Planning Application: **OUTLINE** planning application for the demolition of existing structures on site and construction of 70 new residential dwellings on this site.

Reference: **Y/44/17/OUT**

Location: **Land at Stakers Farm, North End Road, Yapton**

Tree Constraints Plan and Tree Protection Plan

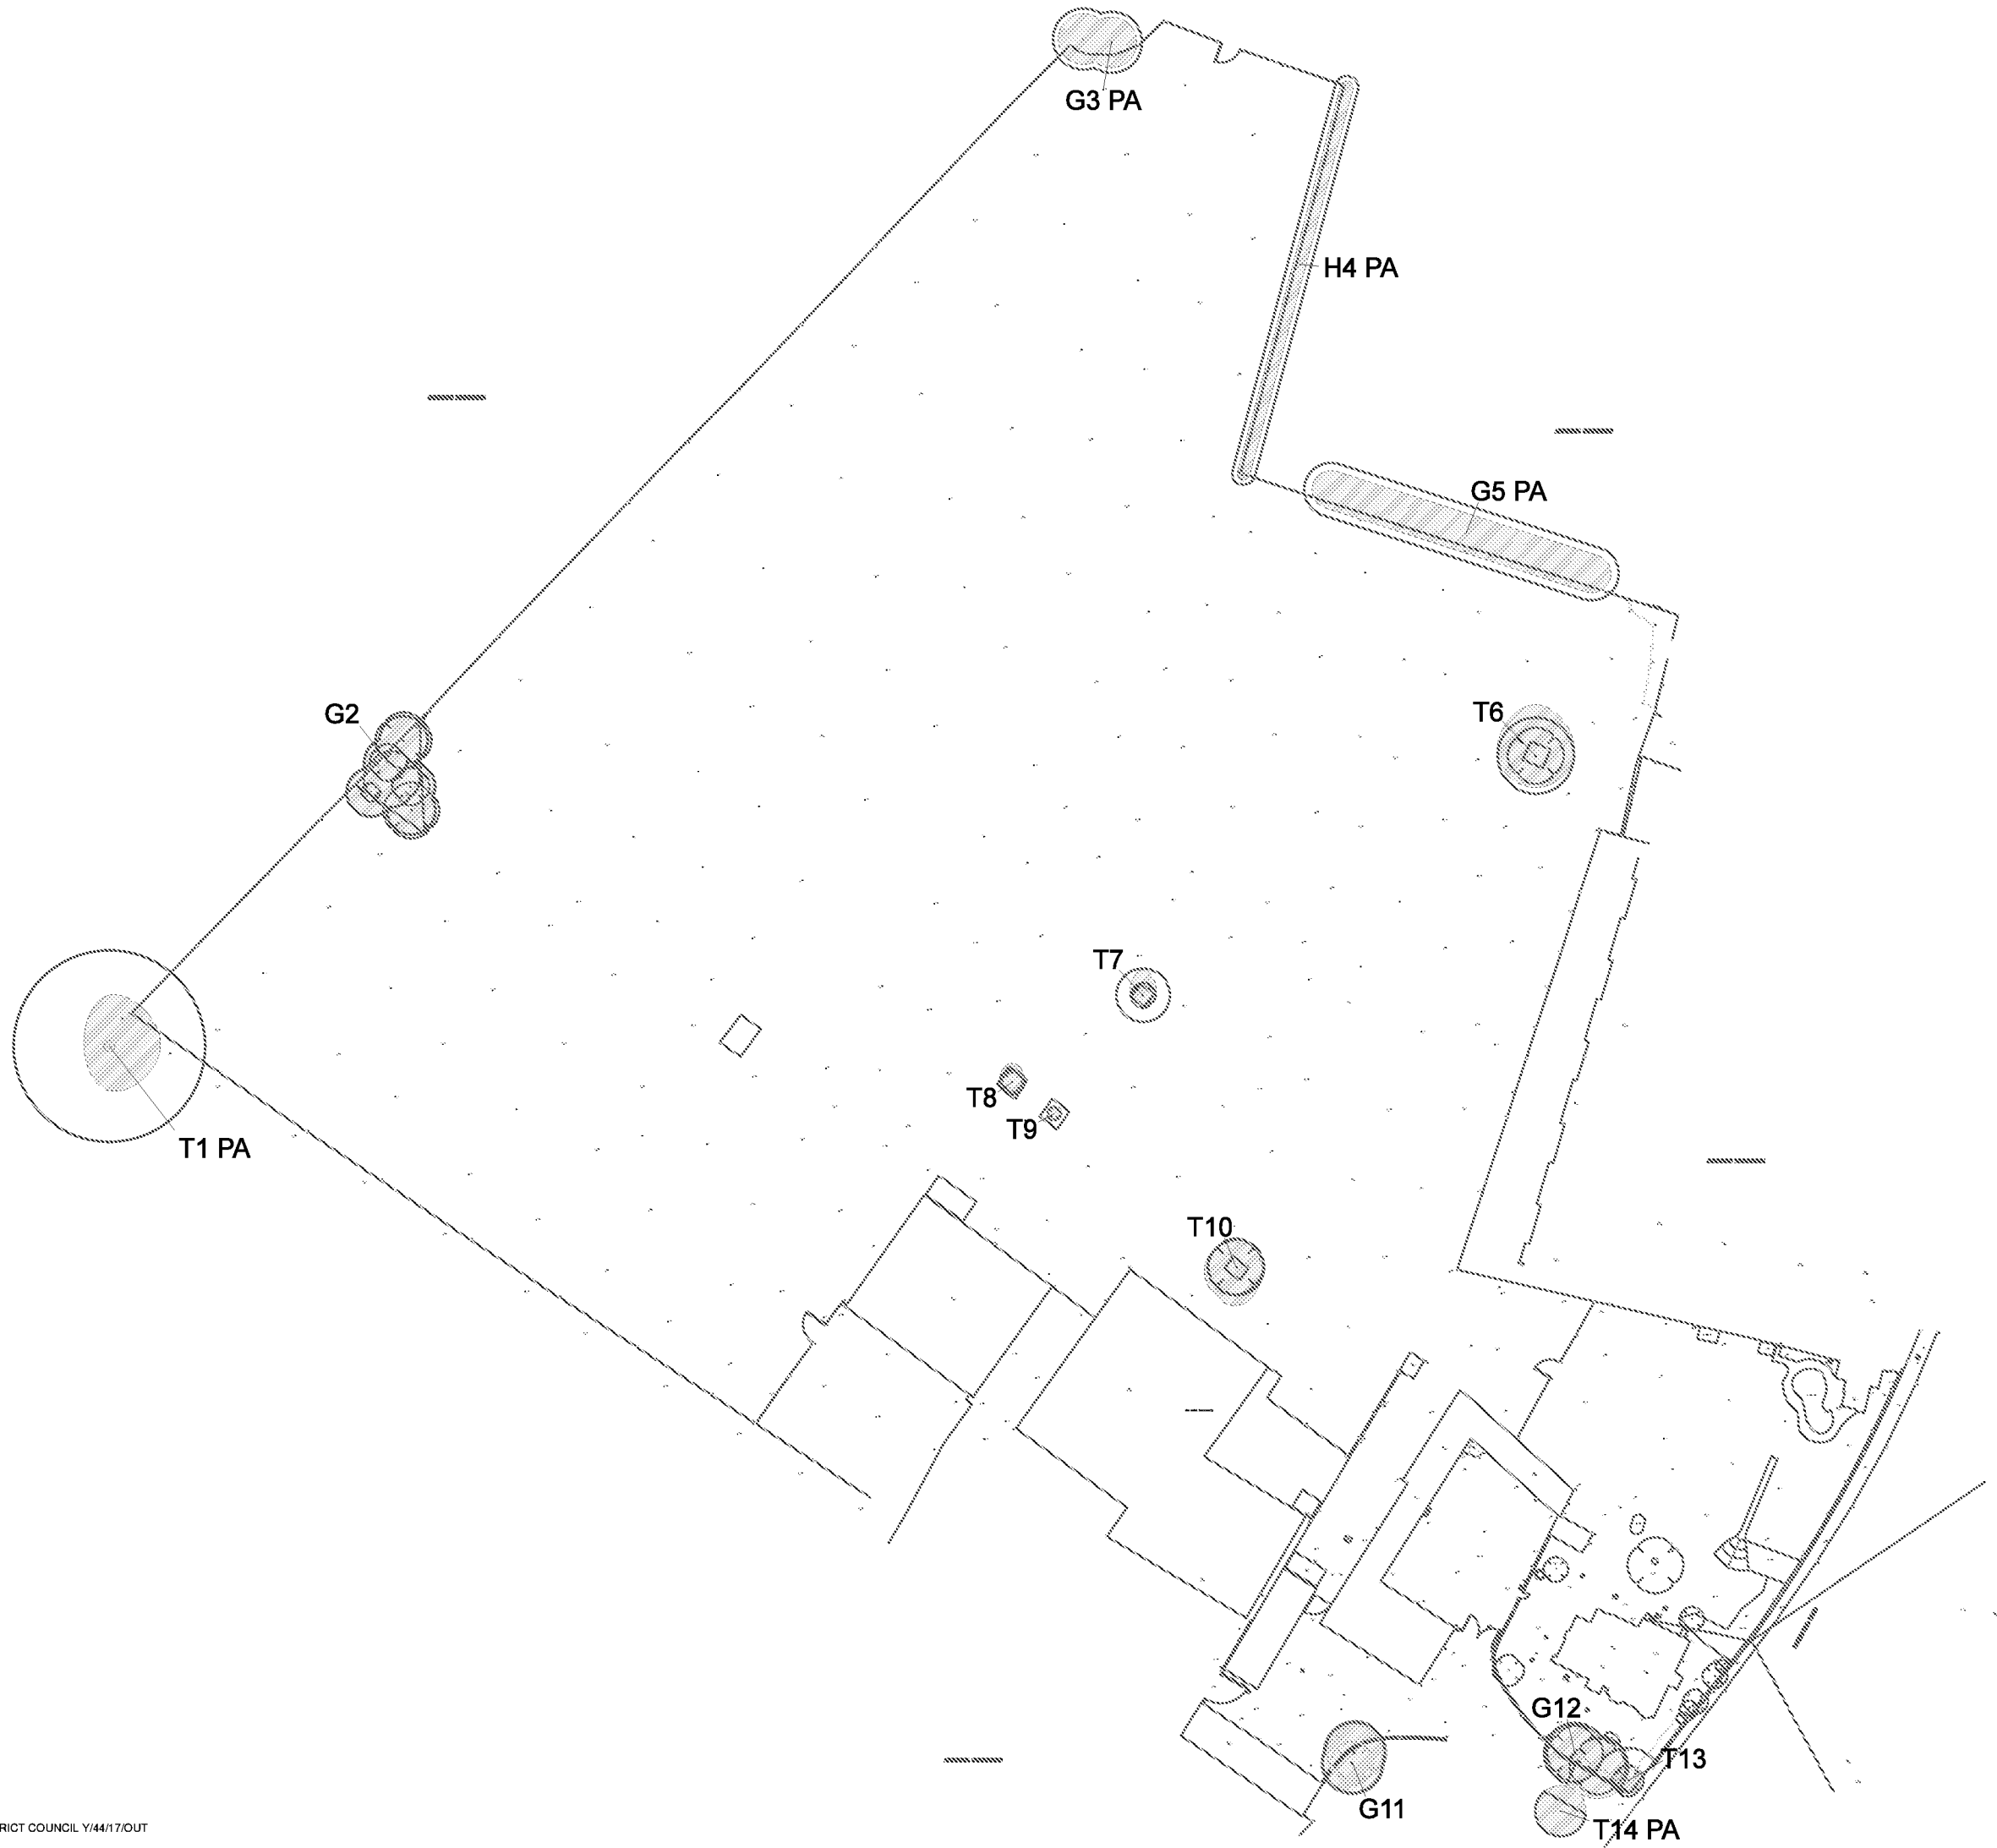
- There are a very few trees of any real significance on this land and none which I would deem as requiring the additional protection of a TPO.
- Studying the layout plans that have been submitted shows that the majority of the tree cover is retained and fully protected behind protective fencing. The three losses are acceptable (7,8 & 9) as well as the Macrocarpa T1 which is a U graded tree.

- A **PRE-COMMENCEMENT Site Meeting** is to take place between the Arun DC Tree Officer and the Arboricultural Consultant representing the site owners – at this meeting all protective fencing will be inspected along with ground protection measures – they will be assessed to verify that they are ‘Fit for Purpose’ as required under British Standard 5837:2012 and have been erected and positioned exactly as shown on the **Tree Protection Plan PJC 4372/17/A Rev 01 – 16th May 2017.**

- I raise **NO OBJECTION** to this scheme provided that the following Conditions are applied :-
1. All demolition & construction works are to be carried out in strict accordance with:- **Arboricultural Method Statement Report Ref: PJC 4372/17-02 -23rd June 2017 and Tree Protection Plan ref: PJC 4372/17/A Rev 01 – 16th May 2017.**
